Ribble Valley Borough Council  
Housing & Development Control

Application no: **3/2023/0022**

Address: **60 Preston Road Longridge PR3 3BD**

Proposal: **Proposed first floor extension and additional parking.**

ROOF SITE PLAN PROPOSED 1500

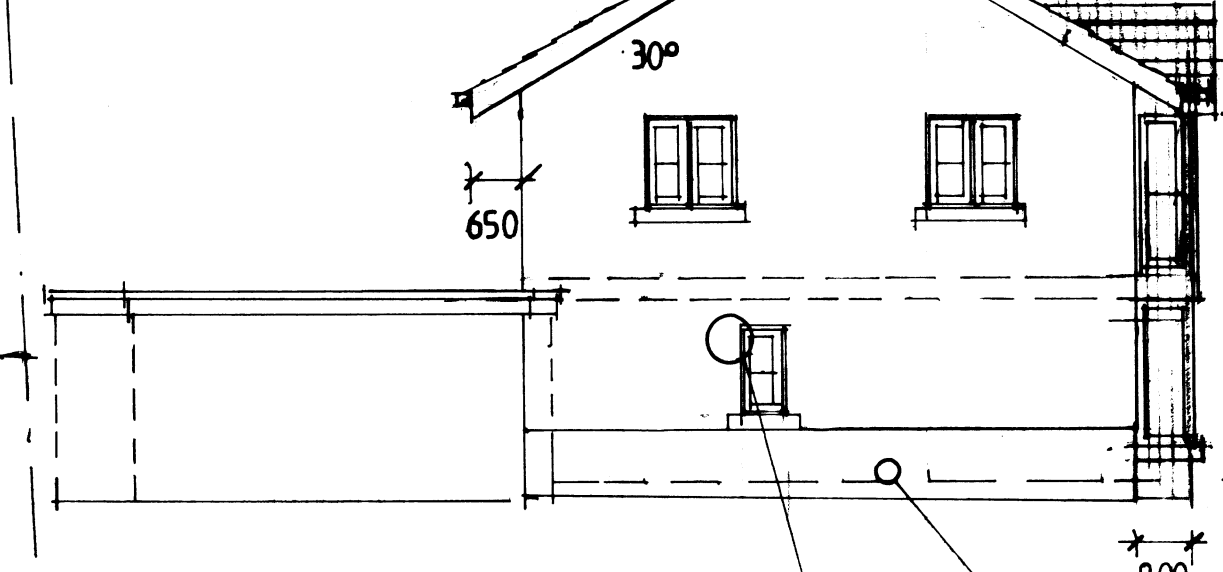
The LHA have reviewed Michael Jackson drawing number 2059/5 titled "Plans Elevations As Proposed" and are aware that 3 car parking spaces will be provided for the proposed 4 bed dwelling, with the number of bedrooms increasing from 3. This complies with the LHAs parking guidance as defined in the Joint Lancashire Structure Plan.

However, the LHA will condition that a new parking plan is submitted. This is because due to the 45-degree orientation of all three parking spaces, the LHA are concerned that there will not be adequate space to exit the site in a forward gear. The need to enter the site in a forward gear is important given that the site is accessed off a B classified road which has experienced multiple reported personal injury collisions in the last 5 years.

Therefore, the LHA advise the Agent that should they prefer the parking spaces to be at a 45-degree orientation, then the spaces should be rotated 180 degrees to enable the vehicle to reverse out of the space and exit the site in a forward gear or alternatively should be at a 90-degree angle, like the traditional car parking space, with the adequate reversing space.

1. Prior to completion, the development hereby permitted shall submit a parking plan to the Local Planning Authority, in consultation with the Local Highway Authority.
